KITTITAS COUNTY COMMUNITY DEVELOPMENT SERVICES

October 25, 2018

Nick Jones
DNR SE Region Engineer
713 Bowers Rd
Ellensburg, WA 98926

Kittitas County Community Development Services (CDS) received your application for a Shoreline Exemption on October 11th, 2018. Upon review of the application materials it has been determined that review under the State Environmental Policy Act (SEPA) will be required, and in order to consider the project for an exemption under the Kittitas County Shoreline Master Program (SMP), additional information will be required.

PRE-CAST CONCRETE BLOCK  
 ABUTMENT STRUCTURE DETAIL  
 NORTHEAST ABUTMENT  
 PLAN VIEW

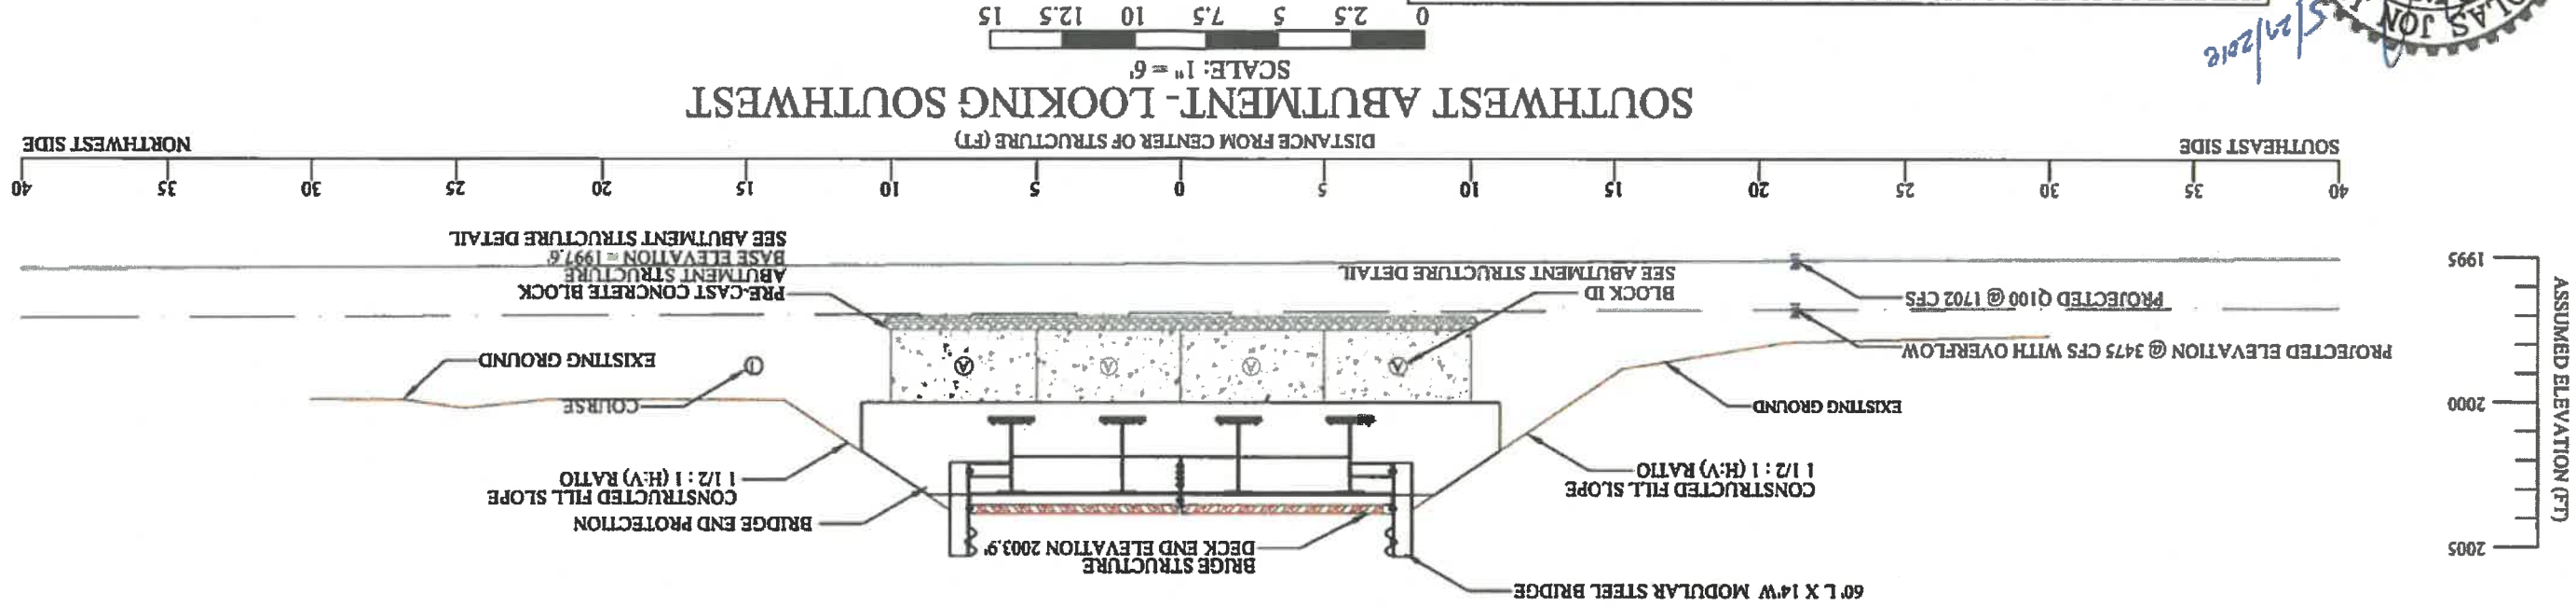
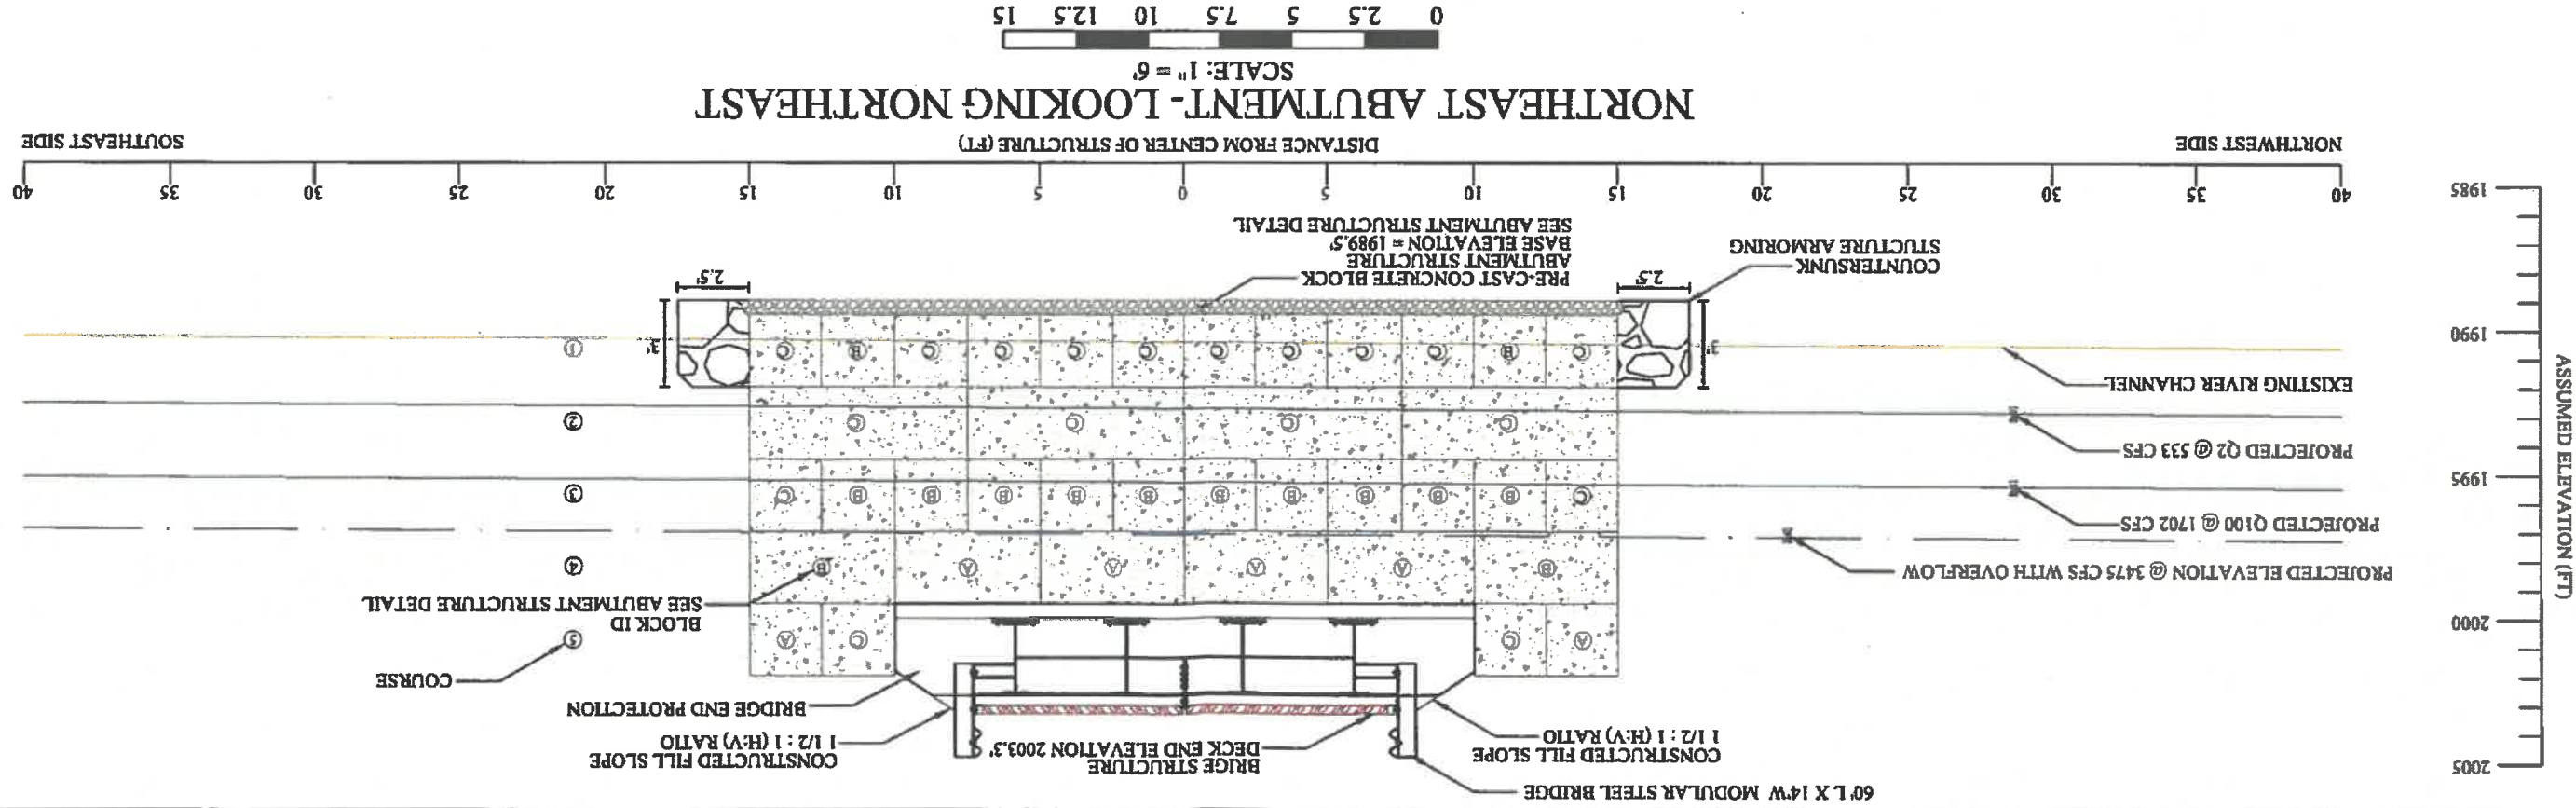
The submitted site plan and engineering drawings not only depict an expansion of the bridge area itself, they also depict new crushed rock abutments and concrete blocks. If they already existed, the proposed project would qualify as “minor repair or replacement” provided that the work remained within the original footprint of the structure, in order to meet the “no material expansions” provision. As proposed, the additions qualify as material expansions and do not qualify as minor repair or replacement.

The above section allows an exemption for “Normal maintenance” and “Normal repair”. Although actions of maintenance and repair are exemptible under the SMP, it is not clear that expansion of the bridge structure and the addition of new abutments and concrete blocks is consistent with “usual acts” for normal maintenance or normal repair to a condition “comparable to its original condition”. Additional information describing this replacement method is necessary to demonstrate it is the industry standard and normal practice for replacement of structurally deficient bridges. If this cannot be demonstrated, then a Shoreline Substantial Development Permit (SDP) will be required.
